# CITY OF ALBUQUERQUE

February 13, 2015

**Re: El Dorado High School  
Construction Drawings for SD tie-in to Embudito Arroyo (G22D004)  
Engineer's Stamp Date 1-16-2015**

DEMOLITION PLAN

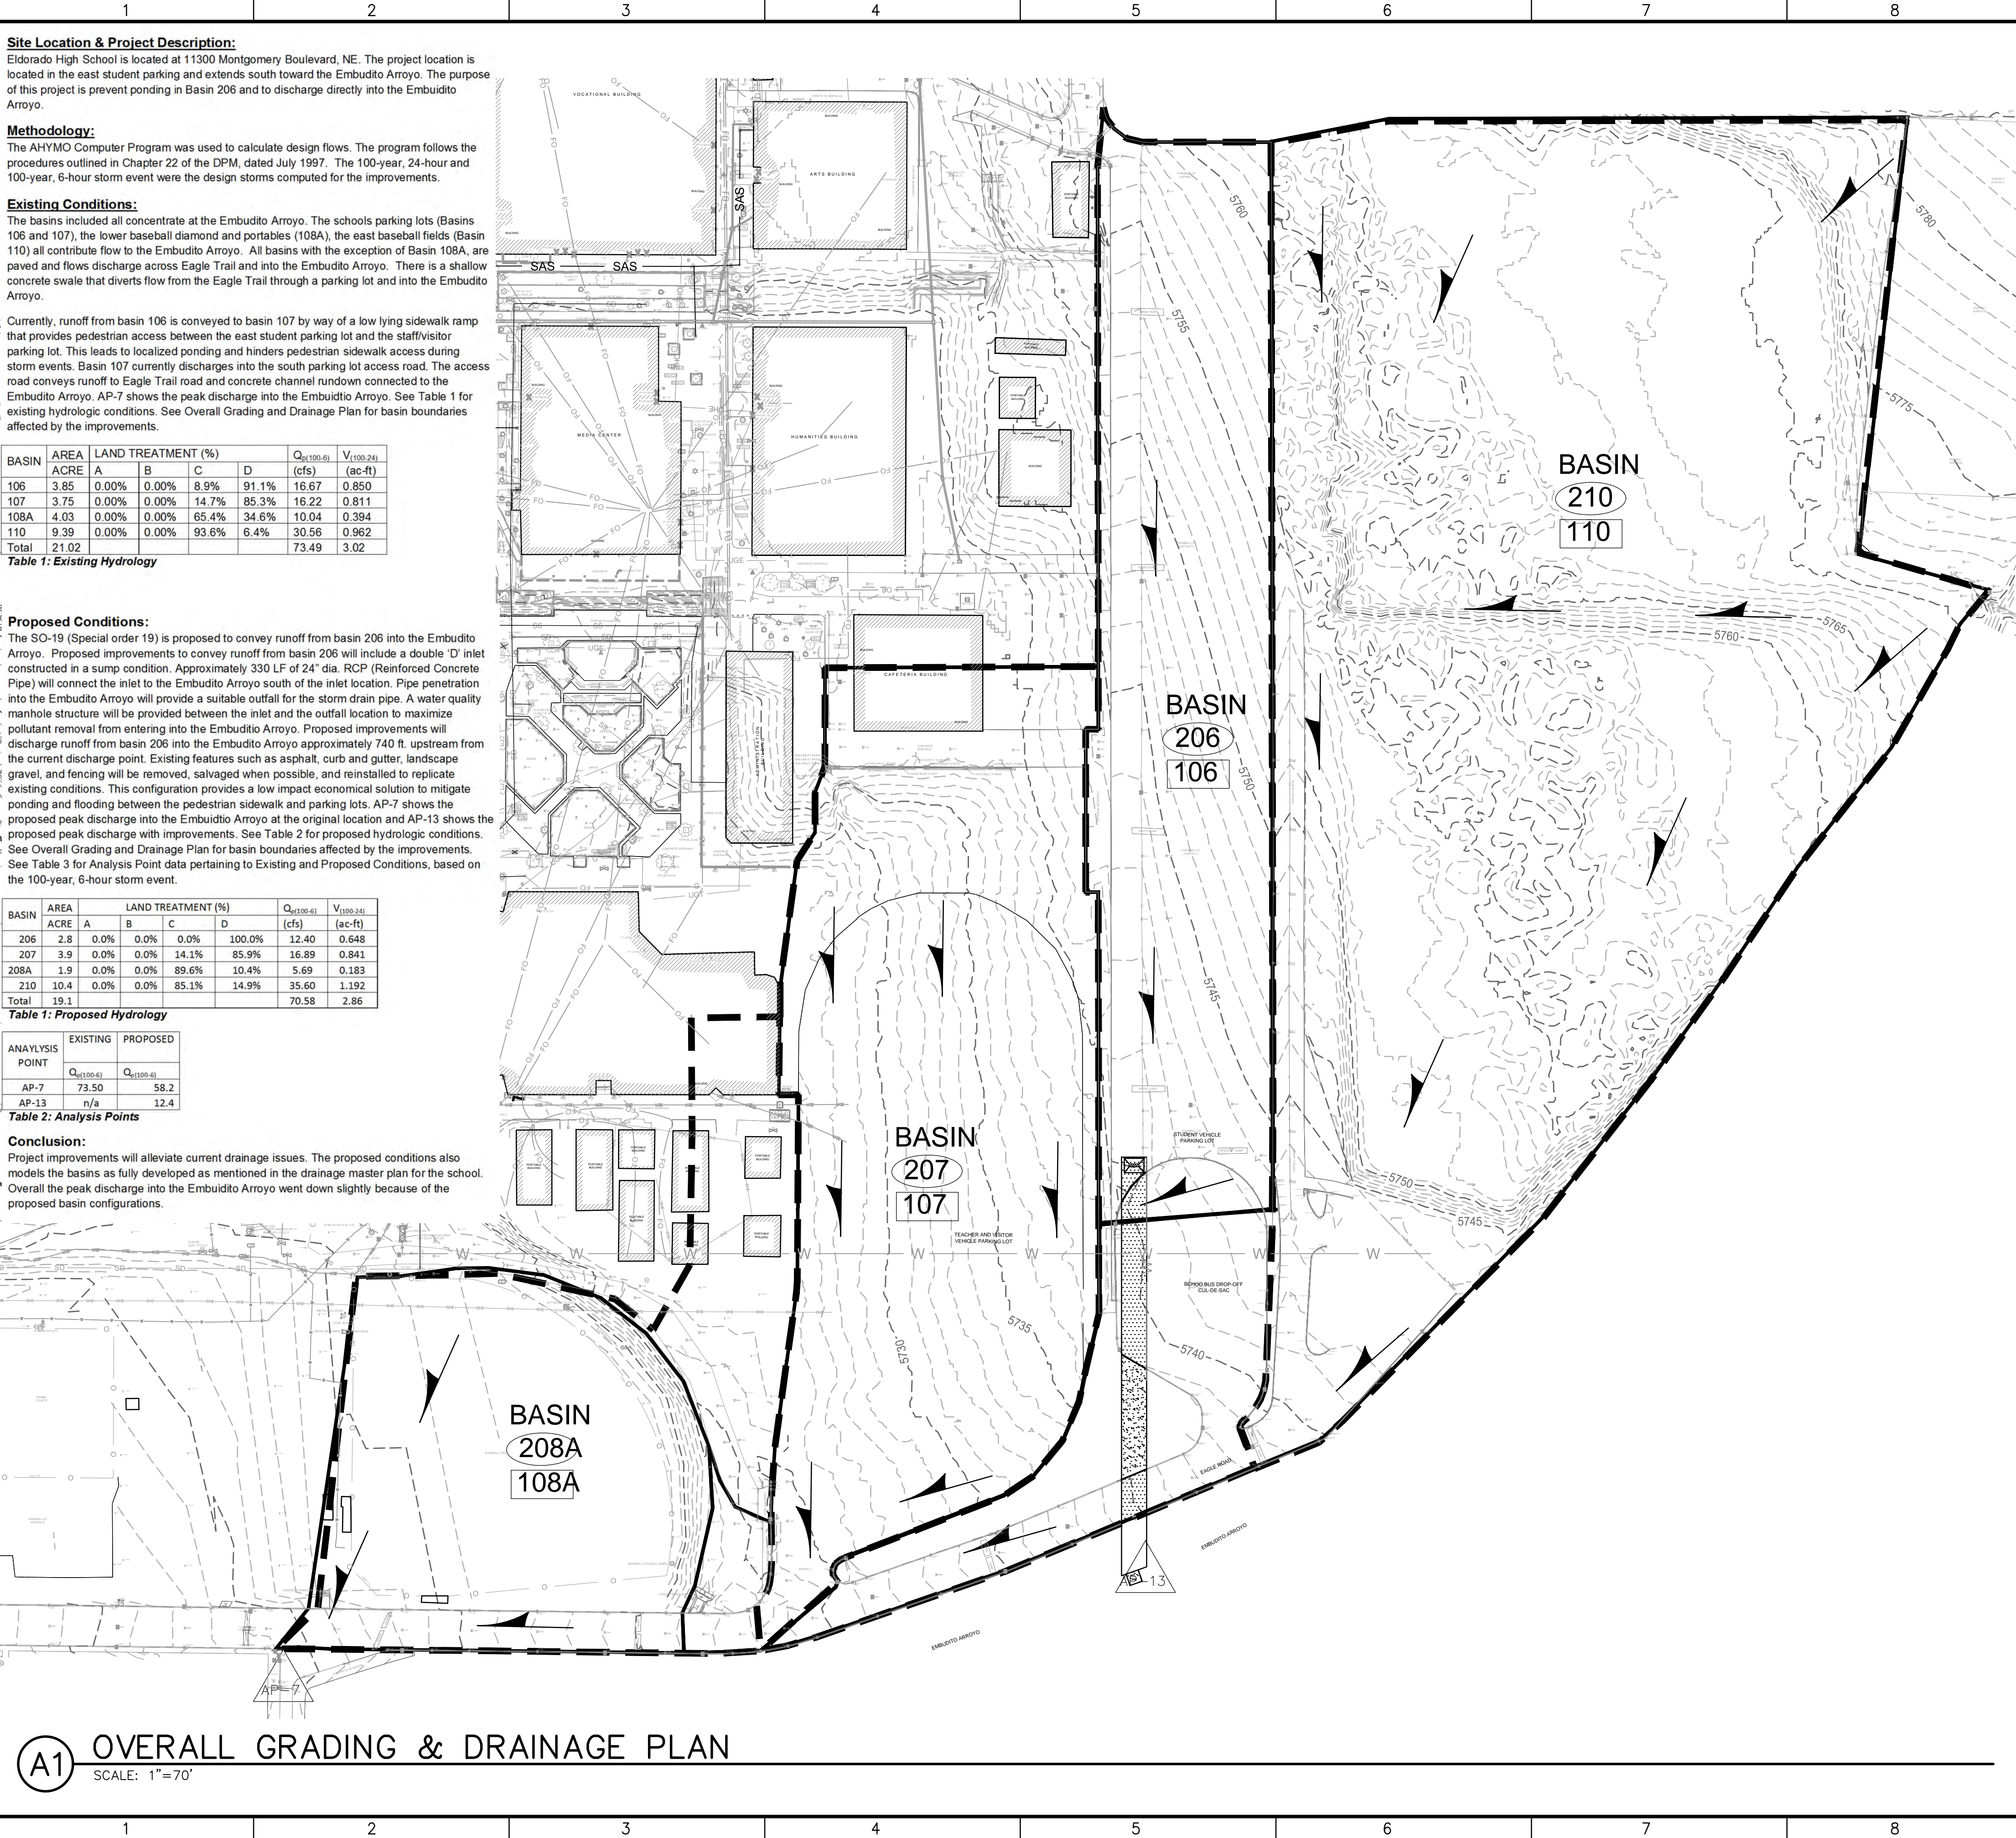
- On Sheet C101, show the extents of demolition at the channel. Show the channel.
- Provide a detail clearly showing the limits of demolition of channel. In order to preserve some length of the channel reinforcing in order to tie it into the new construction, a note may be required stating to "chip the concrete rather than sawcut in order to preserve the reinforcing."
- Water quality manhole is not necessary since plate water quality structure can be installed in the inlet
- Channel penetration detail on Sheet 501 should be modified so that is specific to this situation, shows existing and new construction to scale.
- On the next submittal, only 2 sets of full size construction plans are required.
